Ingleburn Resource Recovery Facility (SSD-8593)
Request for Additional Information

I refer to addendum Response to Submissions Report dated January 2021 for the Ingleburn Resource Recovery Facility (SSD-8593). The Department has reviewed the addendum and is requesting that you provide additional information to aid the progression of the proposal.

Attachment 1

Figure 2-3 Proposed Internal Floor Plan

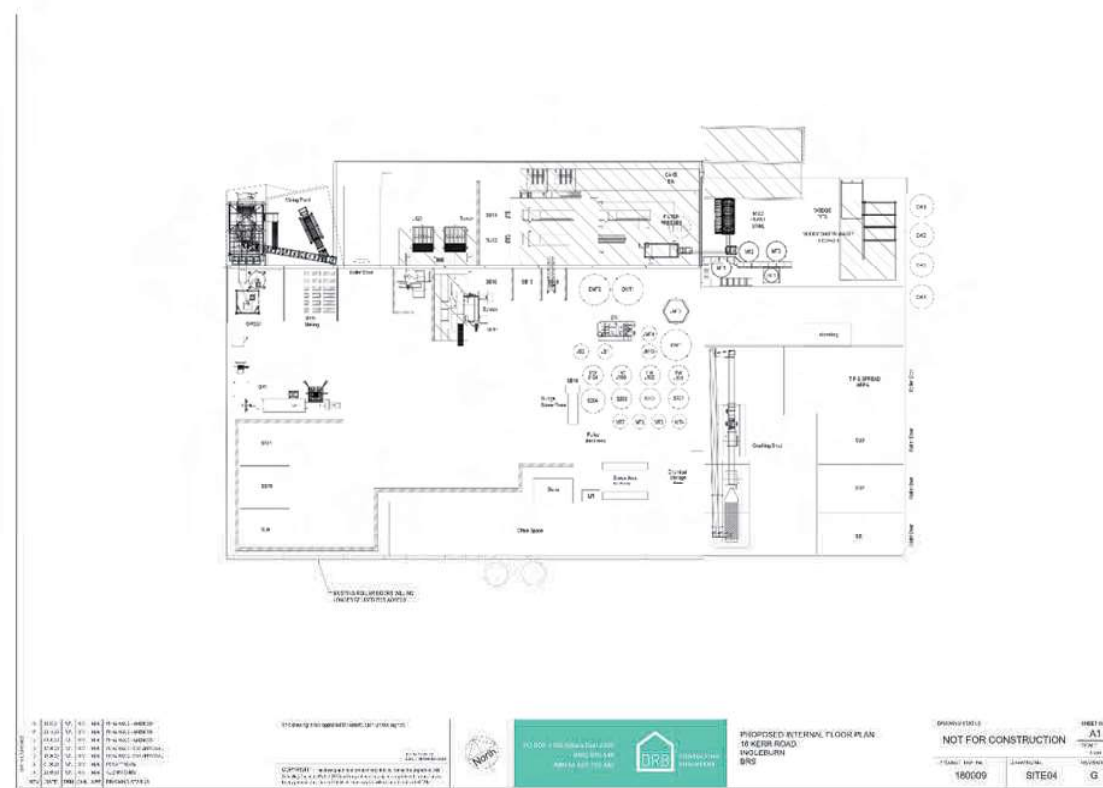
- Provide a final stockpile plan that clearly shows all stockpiles and demonstrates accessibility to SB8.
- Provide a swept path of the longest vehicle that would access SB8-SB11.
- Show on the Internal Floor Plan where non-conforming waste would be stored.
- Update the site plans/waste matrix to include municipal waste, commercial waste, slag, leachate, groundwater, fly ash, grit and crushed glass.
- Provide an architectural drawing of the noise wall.
- Please specify which plan shows the lab as it is not labelled.
